Rezoning Transportation Analysis

Petition Number: 2020-112

General Location Identifier: 04711109

Date	Description
09-11-20	First Review (EL)
04-15-21	Second Review (EL)
8-25-21	Third Review (BB)

RZ-4.0

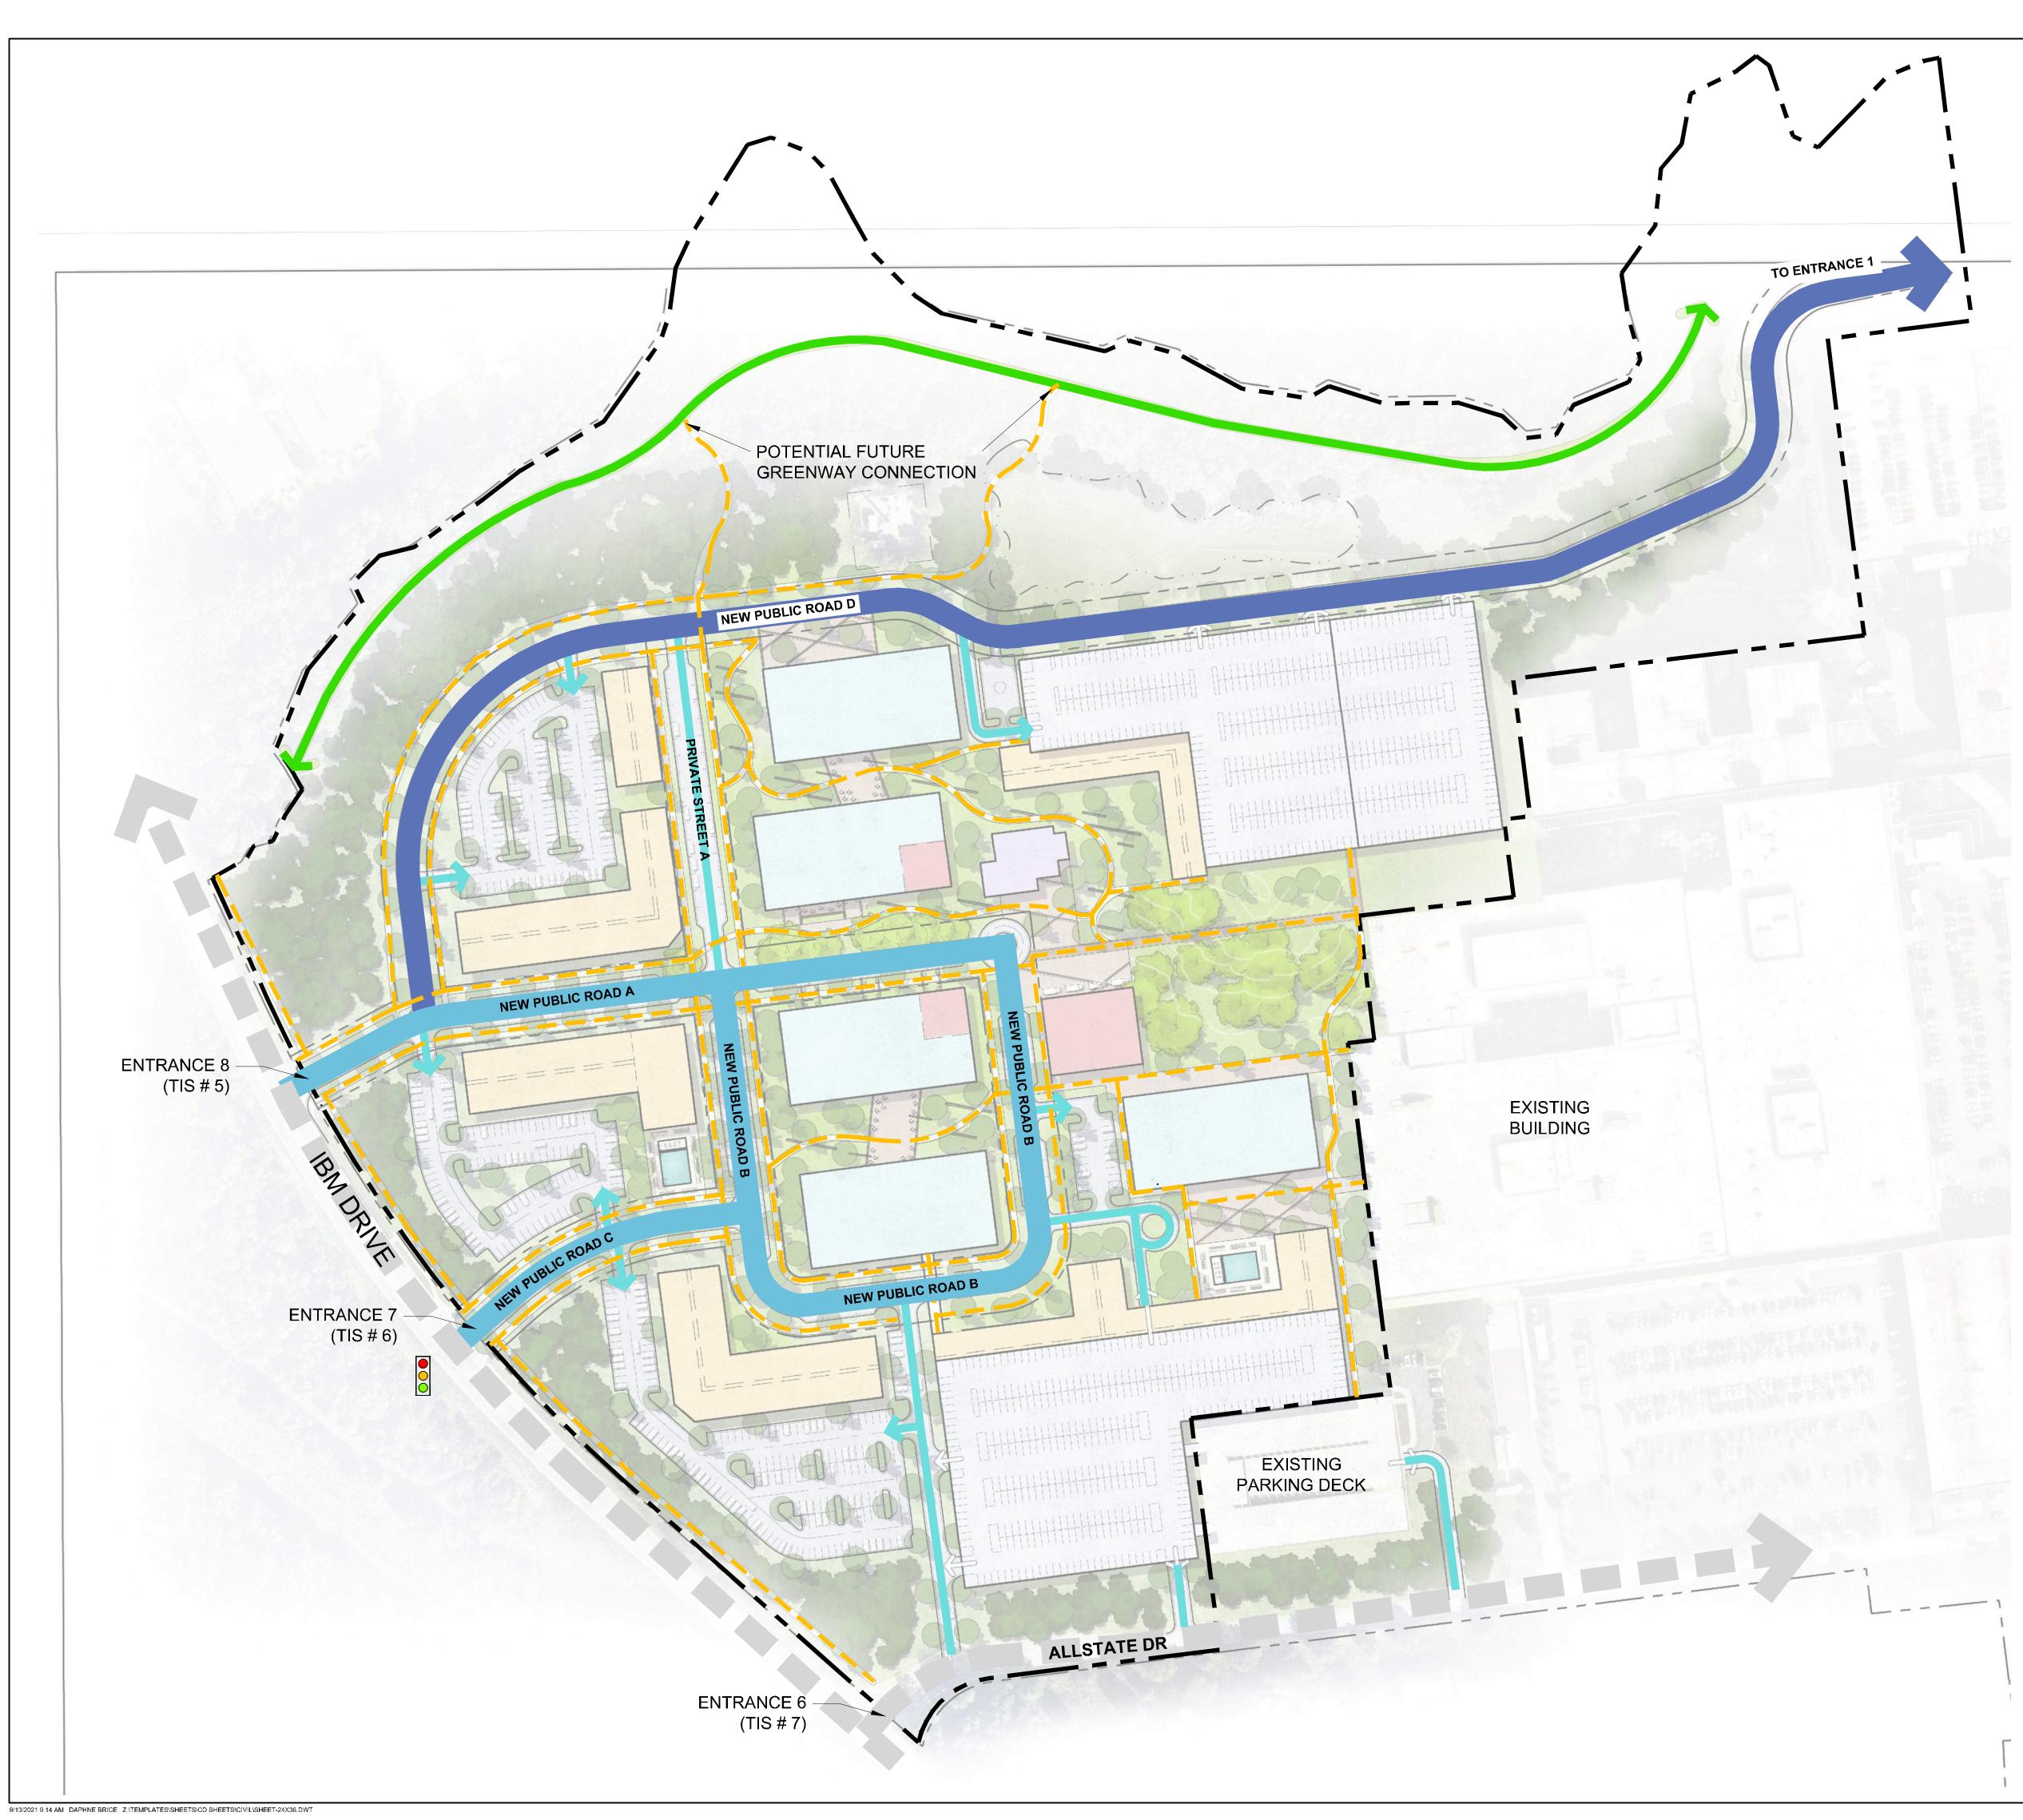
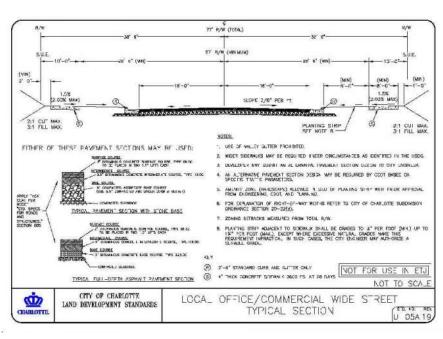
- Updated Comment (Site plan dated 8/16/21):** Revise "Proposed Public Road D" cross-section to include a 4-6' bike lane. The site plan and conditional note(s) need to establish a street connection, as shown below, according to the proposed avenue cross section that is recommended within the University Research Park Area Plan. Refer to pages 38 and 41.
